From: Samantha Legg <Samantha.Legg@lincolnshire.gov.uk>
Sent: 29 December 2025 12:14
To: _planningadvice
Subject: FAO - Sam Dewer re. H16-0692-25

Following the re-consultation for the above application and our interim comments.

Although they have largely addressed our previous concerns regarding the highway improvements, the comments below are to be addressed:

Appendix E
Traffic Flow Diagrams

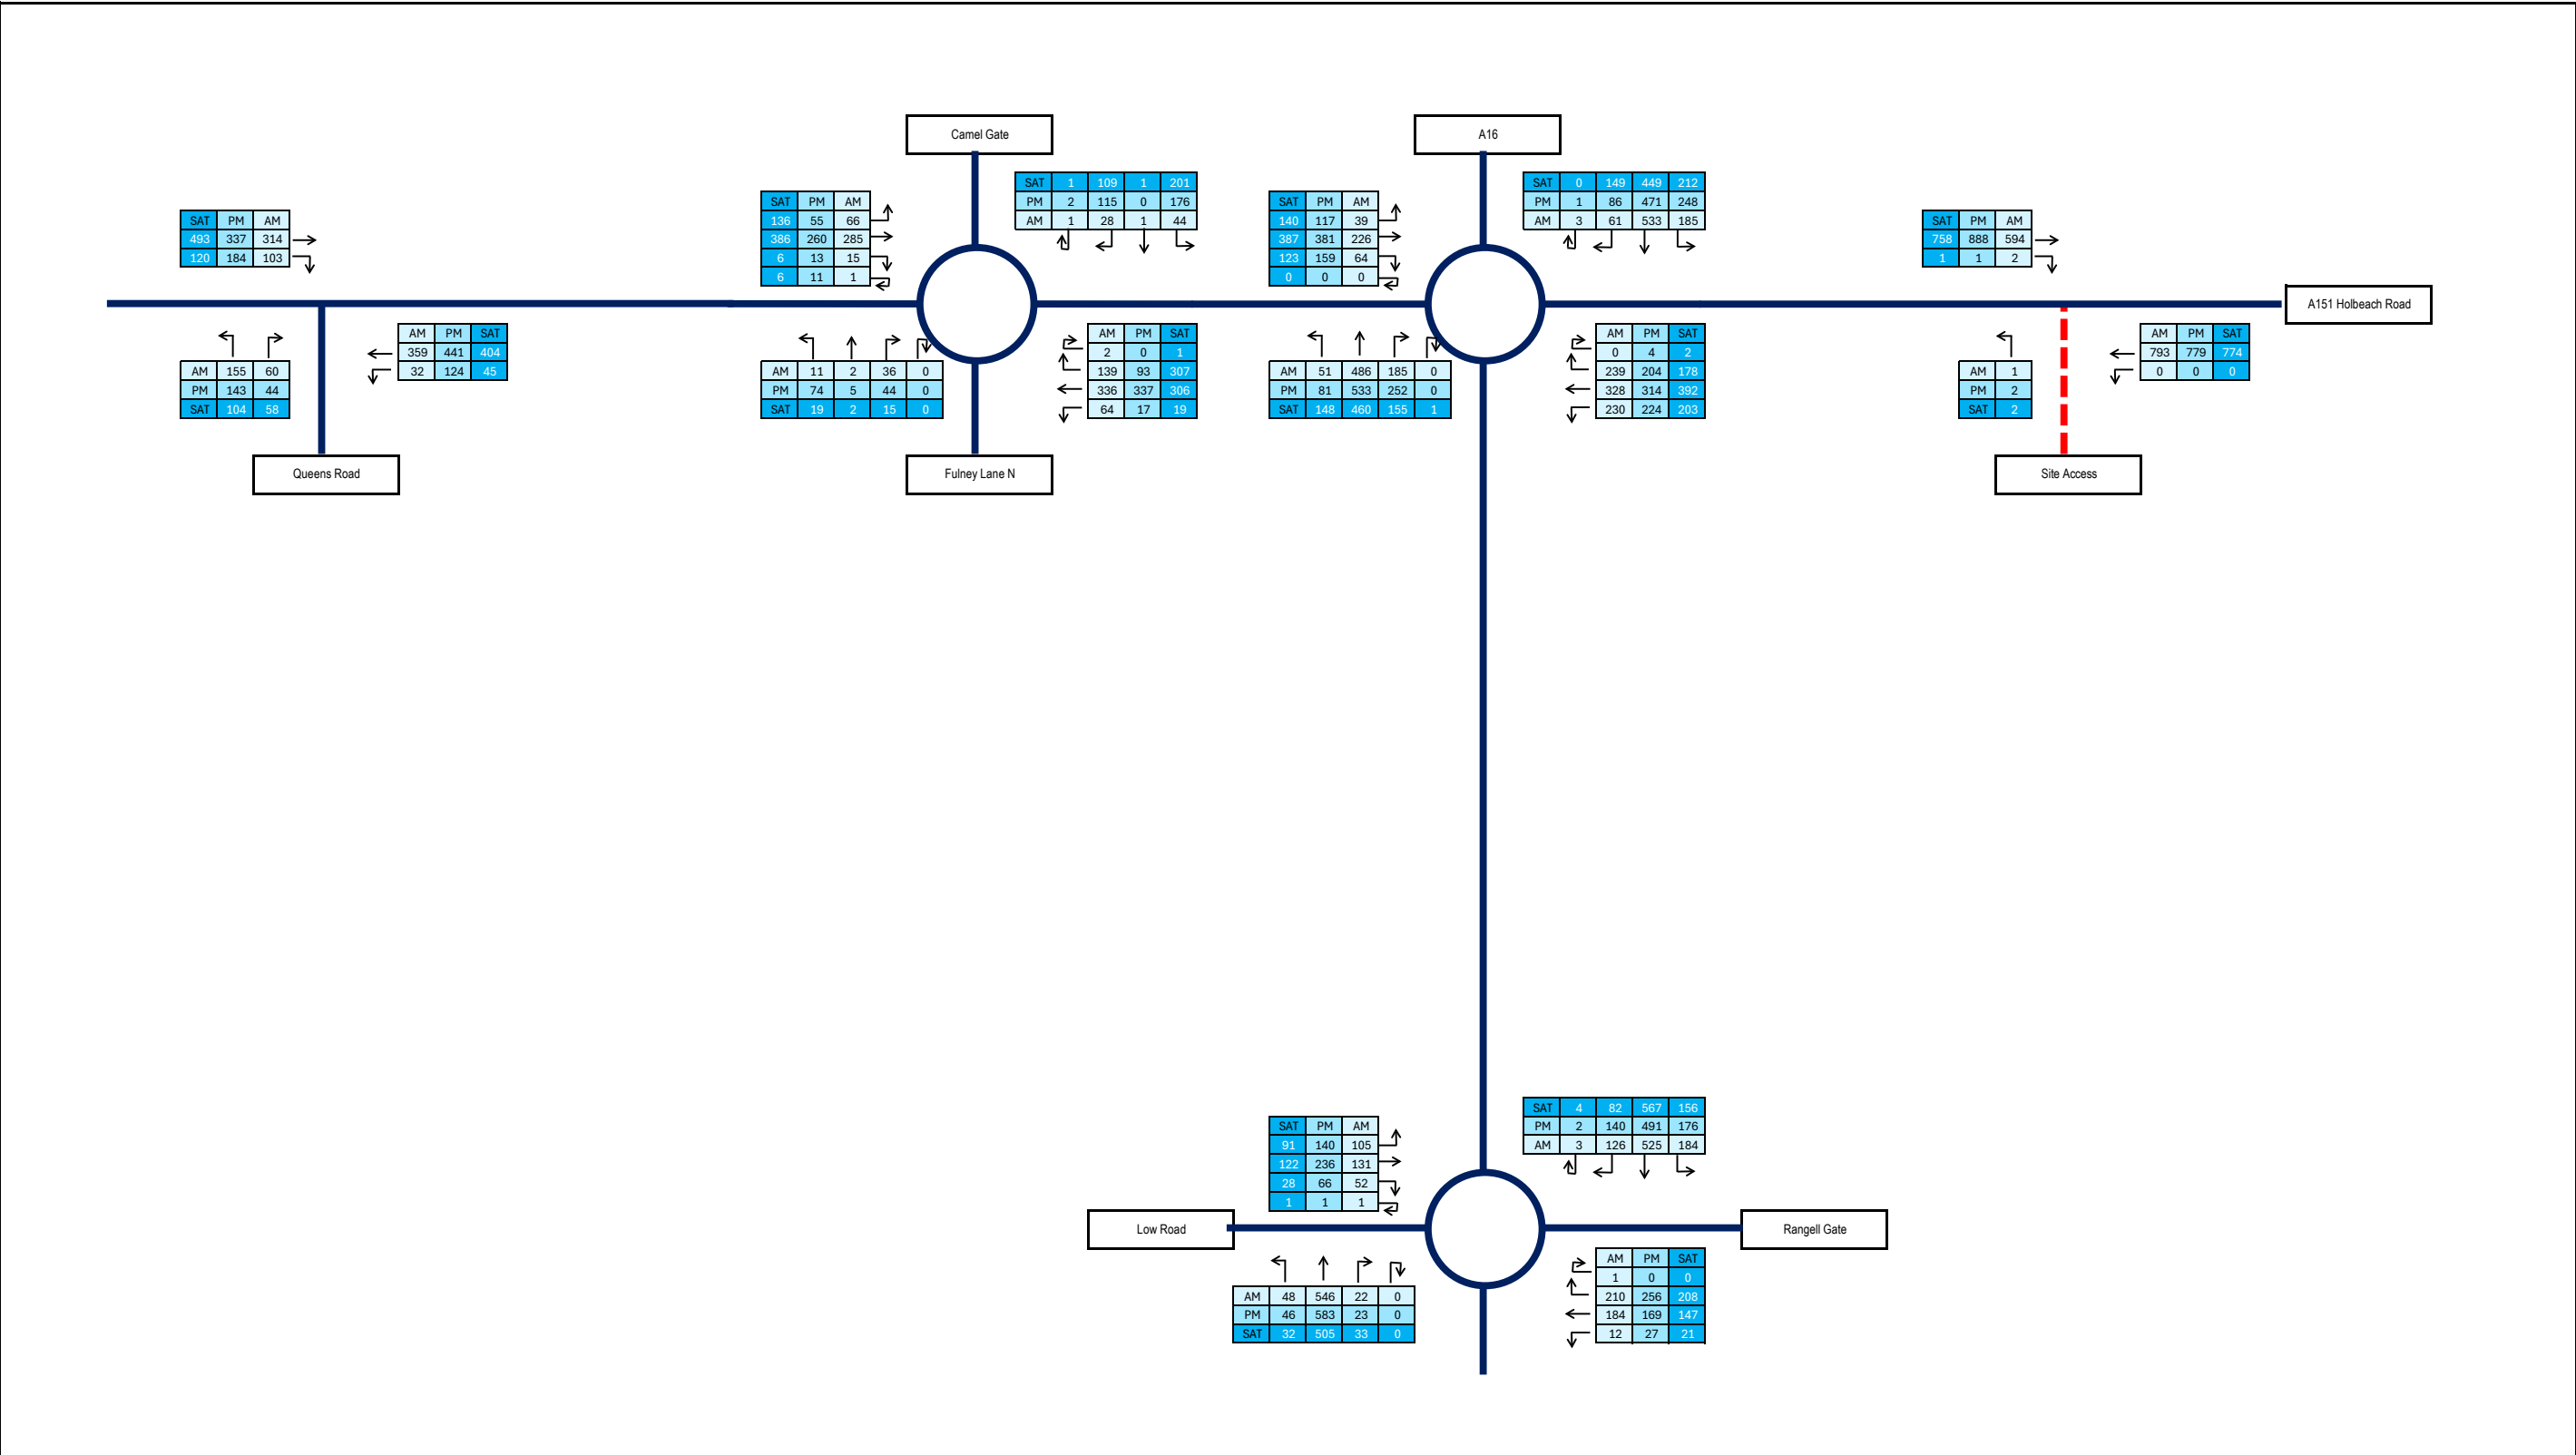
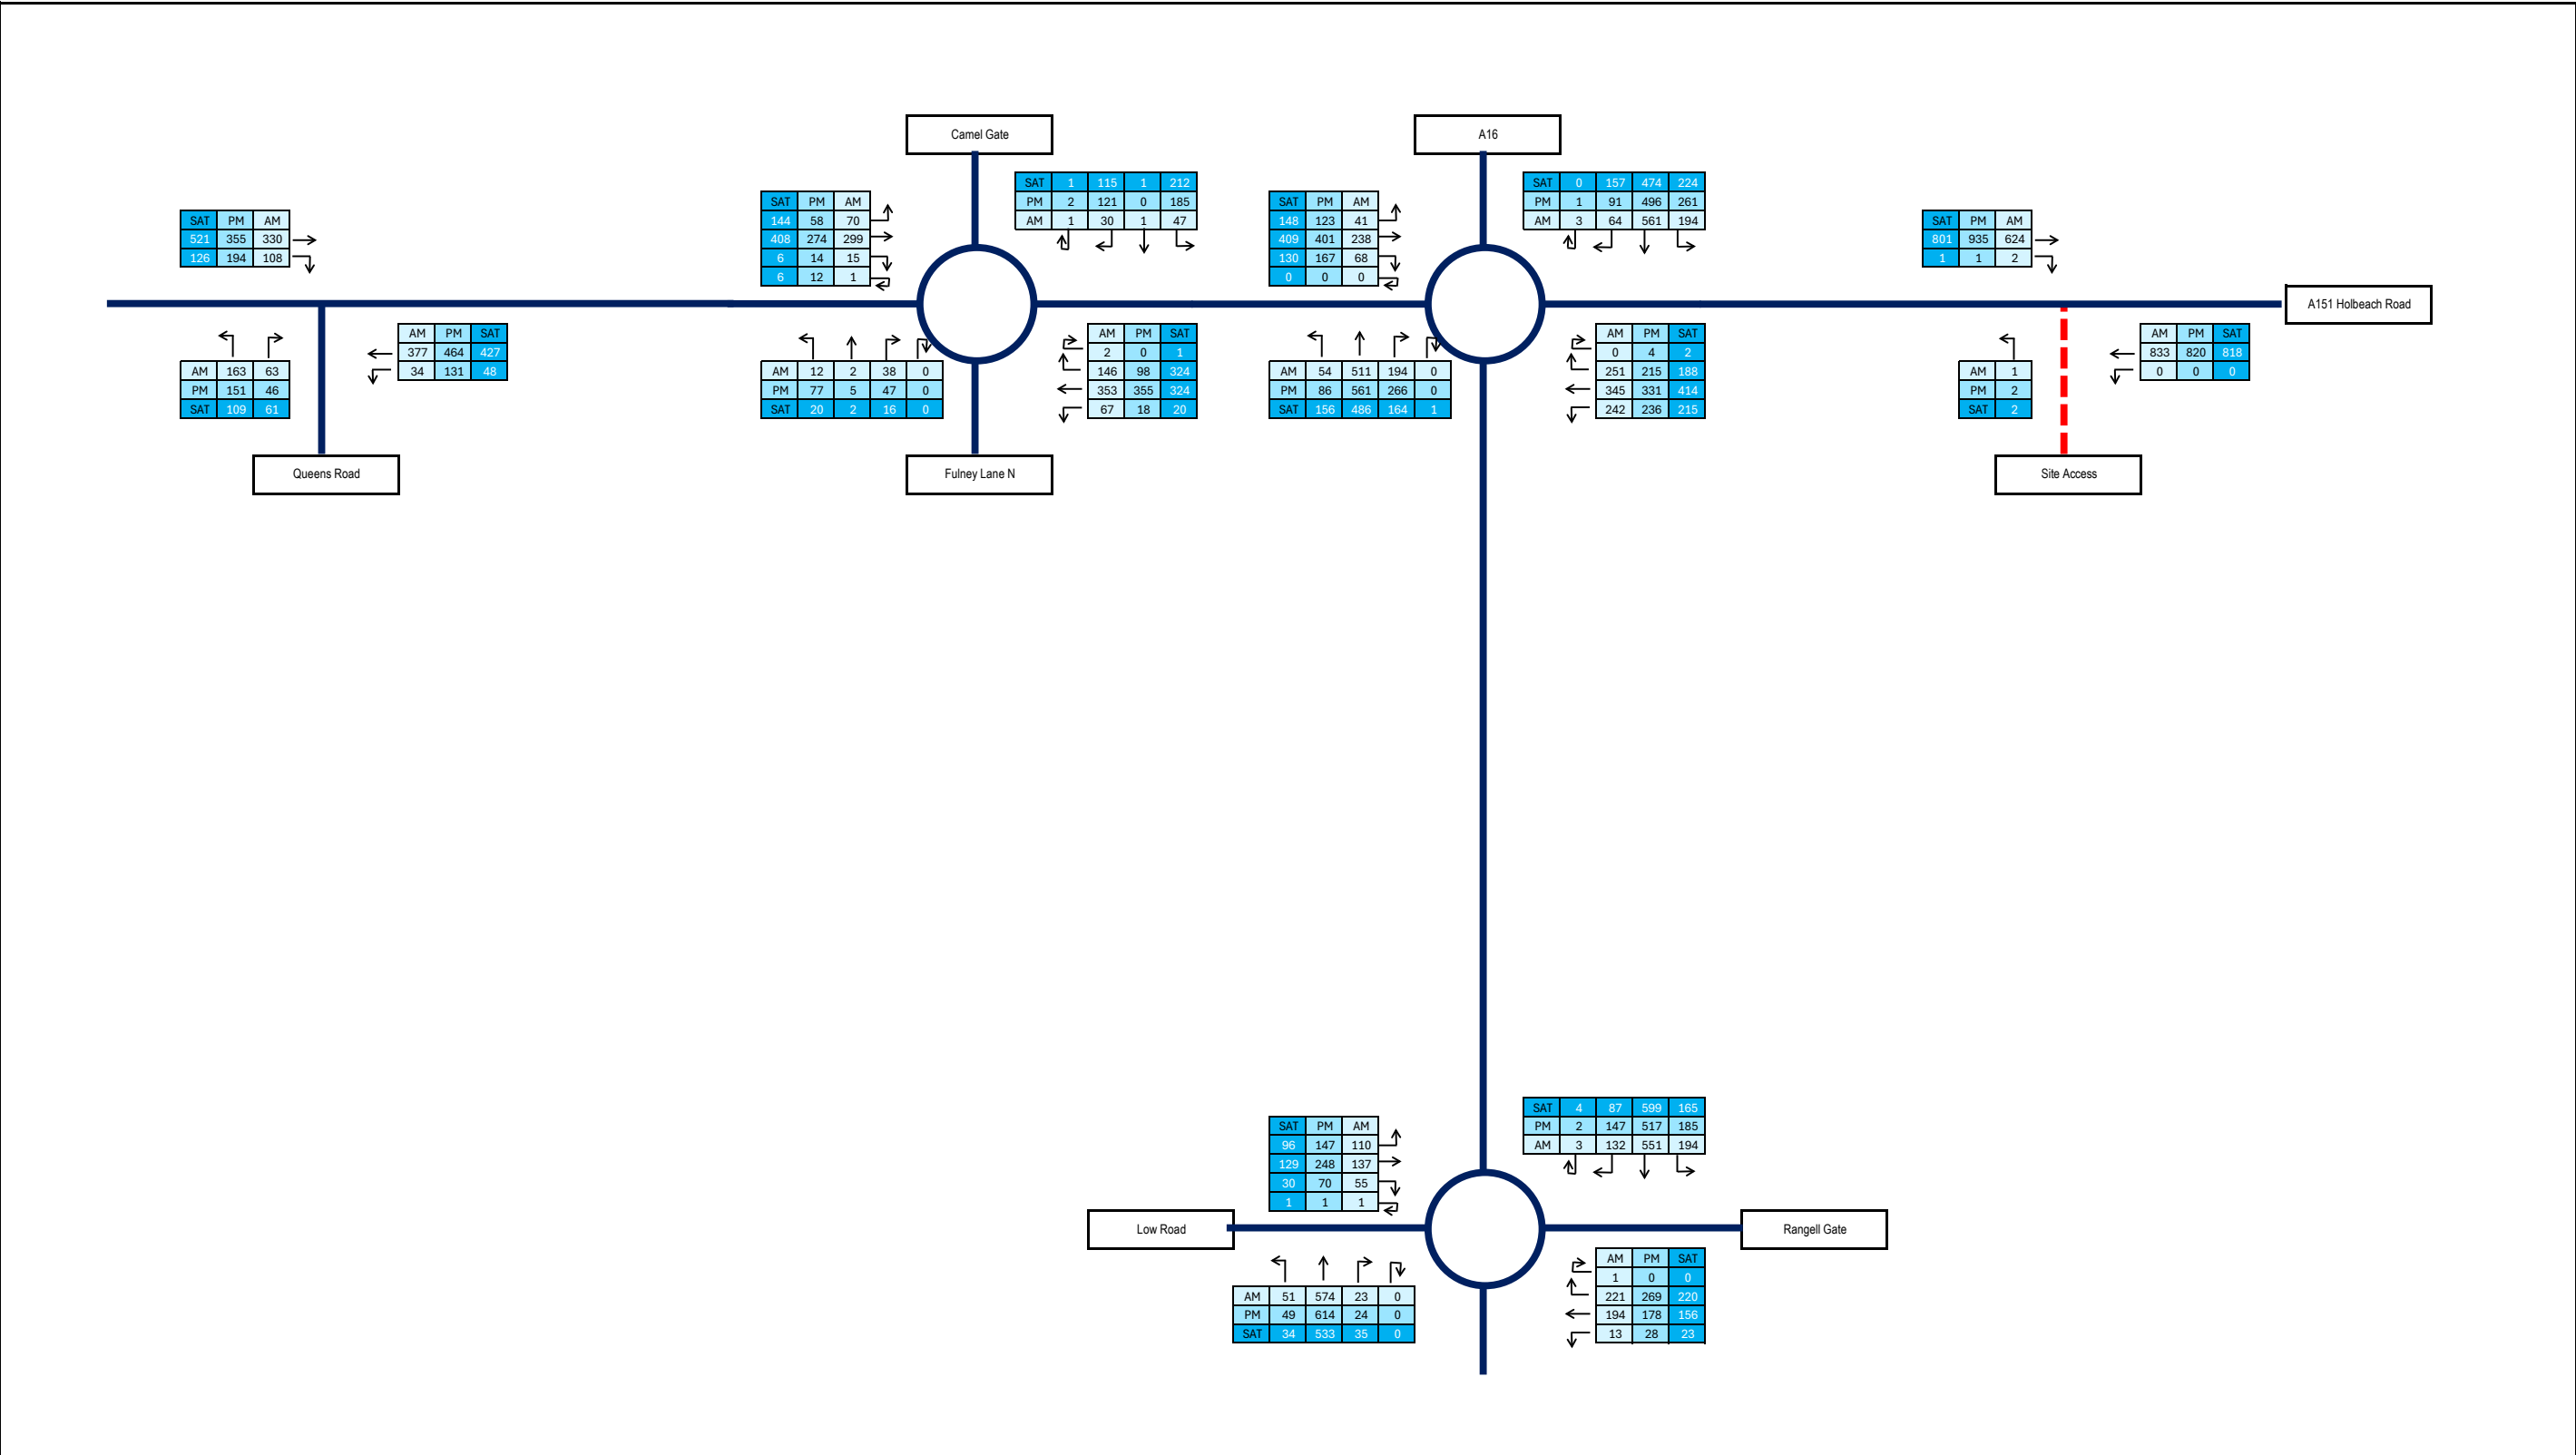
The Transport Assessment does not address safety and the accident data detailed is out of date. Concerns internally with queuing – particularly with it being a Drive Thru and how they operate. There should be a right turn lane internally to the Coffee Drive Thru so that queues internally do not back up into the highway. THIS HAS NOT BEEN ADDRESSED - If people are waiting to enter the Drive thru on the access road, then vehicles will not be able to access the foodstore hence why the drive thru needs its own right turn lane.
